Planning Application No: 3/2024/0949

Proposal: Proposed single-storey rear extension and new roof over existing kitchen and garage. Alterations to existing front boundary wall and new extended drop kerb.

Location: 65 Mitton Road Whalley BB7 9RY

The submitted plans and highway related documents have been viewed and the following comments are made.

Proposed Front Elevation Boundary Wall

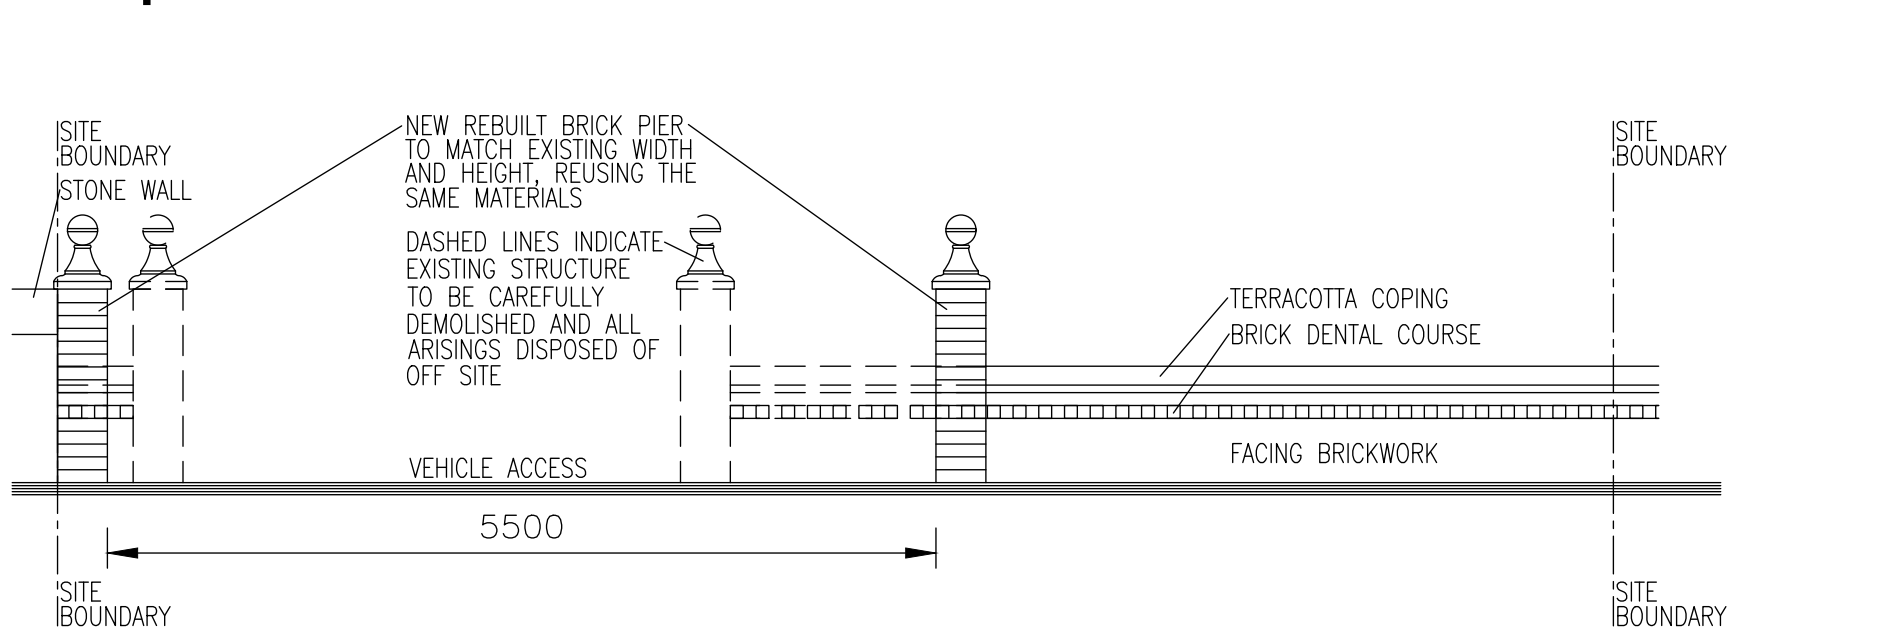
It should be noted that the applicant will be liable to the full cost of any relocation of street furniture/service boxes which conflict with the proposed vehicular crossing.

- The proposed development should not be brought into use unless and until the parking area has been constructed, laid out and surfaced in bound porous materials. The parking area shall thereafter always remain available for the parking of domestic vehicles.
- Prior to work starting on site a construction management plan is produced for approval. This should highlight how deliveries during construction will be managed and where workers on the site will park during construction. Reason: to minimise the impact of construction on existing residents and pedestrians in the vicinity of the site.
